Re. Hera Gold Mine Modification 6 (MP10_0191-Mod-6)

I refer to your request of 25 November 2020 for advice regarding the Hera Gold Mine Modification 6 report. The Resources Regulator has reviewed the request.

# APPENDIX 4 REHABILITATION PLAN

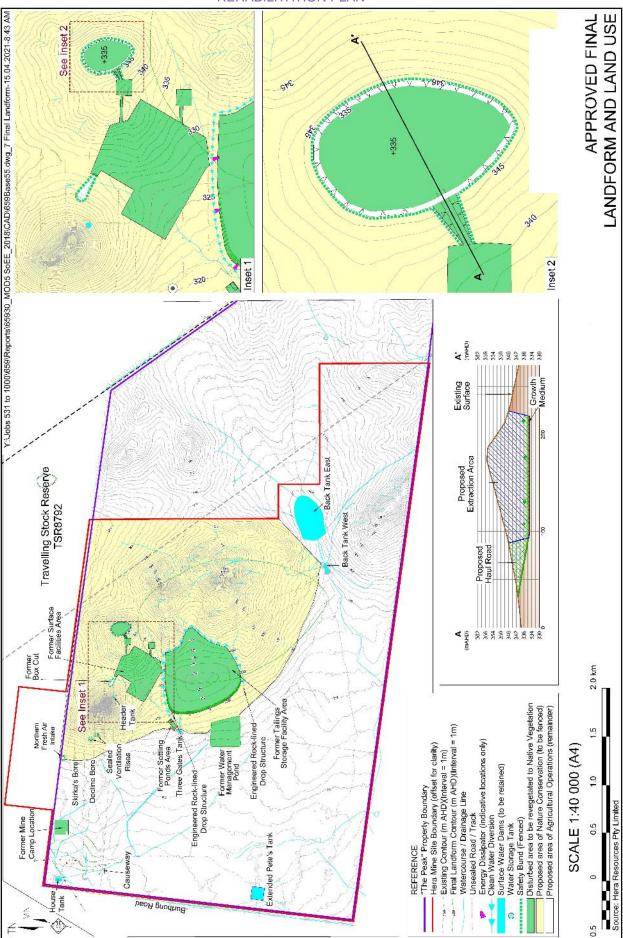
Figure 13 Proposed Final Landform and landuse should be updated to include a clear indication of final landform across the surface extraction area, including contours of the perimeter sloped landform or highwall.
